The London Resort Development Consent Order

Appendix 12.5 Consultation responses to the 2020 EIA Scoping request

Document reference: 6.2.12.5
Revision: 00

Appendix 12.5 Consultation Responses to the 2020 EIA Scoping Report (Relevant to Terrestrial and Freshwater Ecology)

project title
The London Resort

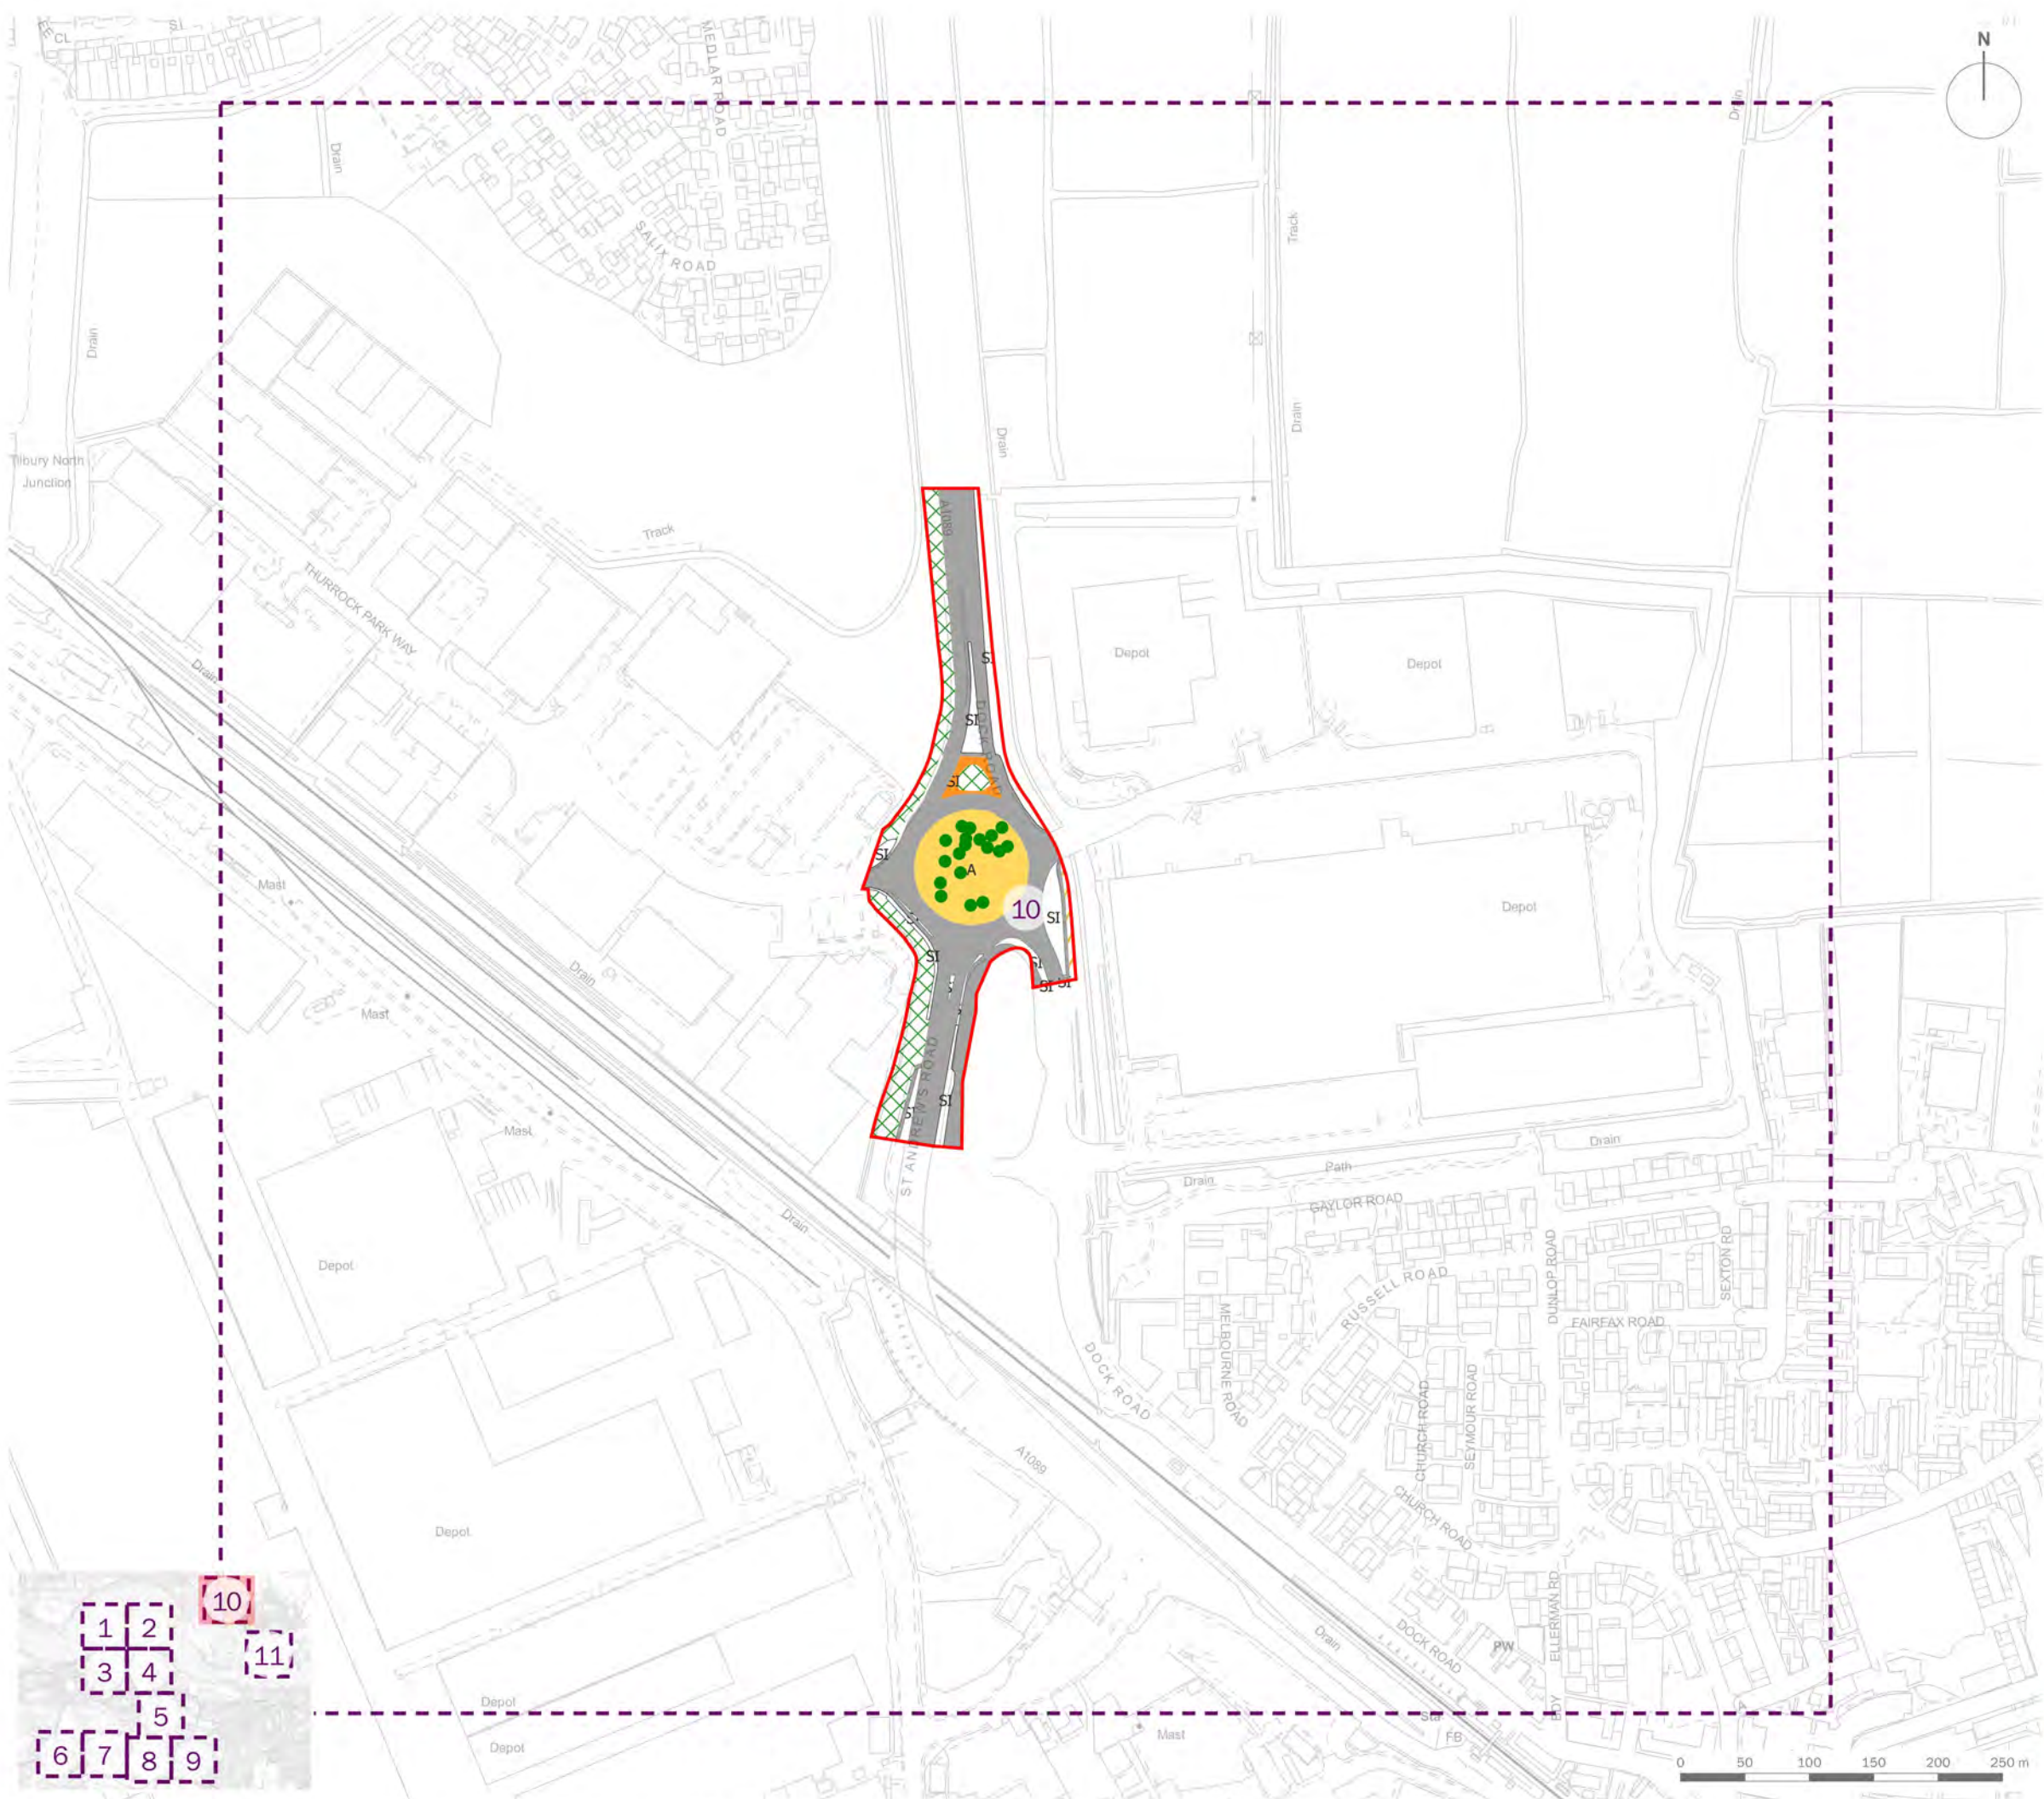
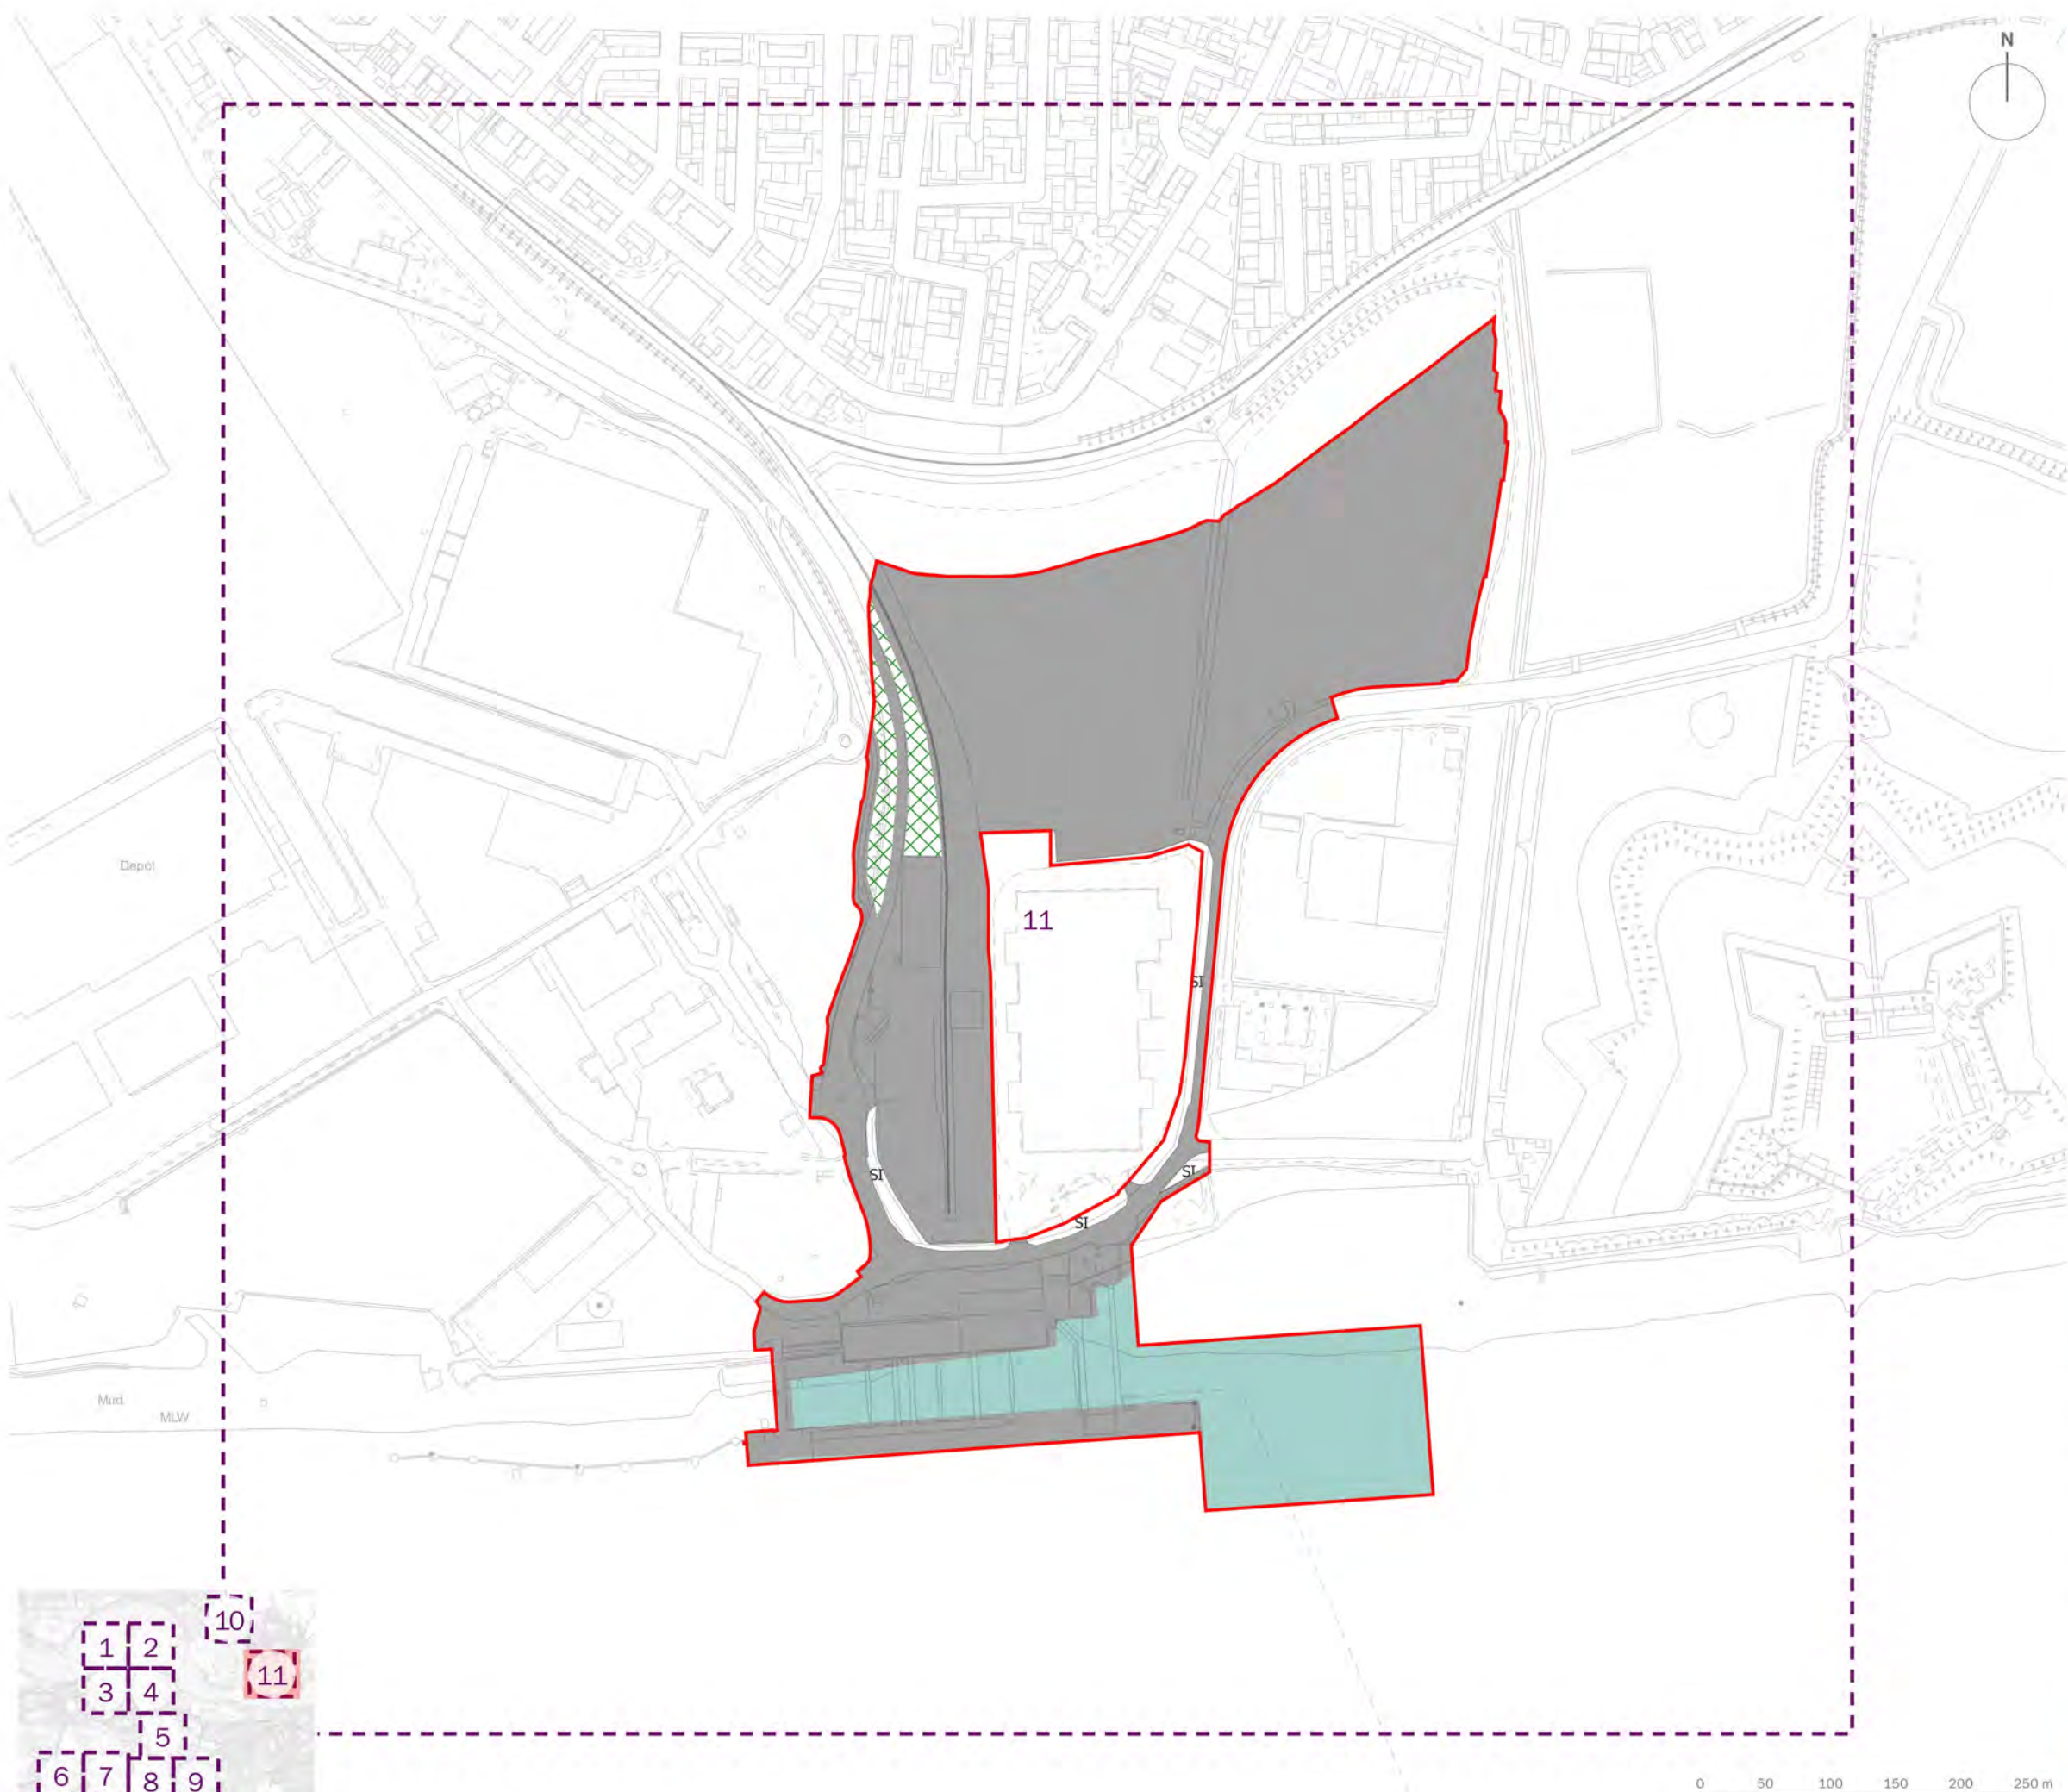
Phase 1 Habitat Plan		Drawing number edp5988_d047 lists the Thames as standing water. It is not and that reference will significantly affect how the Thames is assessed particularly for navigation. Mud will also extend beyond the low tide level.	The Phase 1 Habitat Plan has been updated to show the River Thames as moving water (tidal), with direction of flow indicated. It is acknowledged that mud extends beyond the low tide level, but for the purposes of the Phase 1 Habitat plan, the extent of intertidal mud running to the low tide level is considered sufficient.
	WFD within ES		Reference to the Water Framework Directive (WFD) is spread across three different chapters of the Scoping Report and it is not well cross-referenced which makes it confusing to follow. The terrestrial and freshwater ecology chapter of the ES is one place where the WFD is mentioned.	References to the WFD have been reviewed as part of updating the Environmental Statement ready for submission
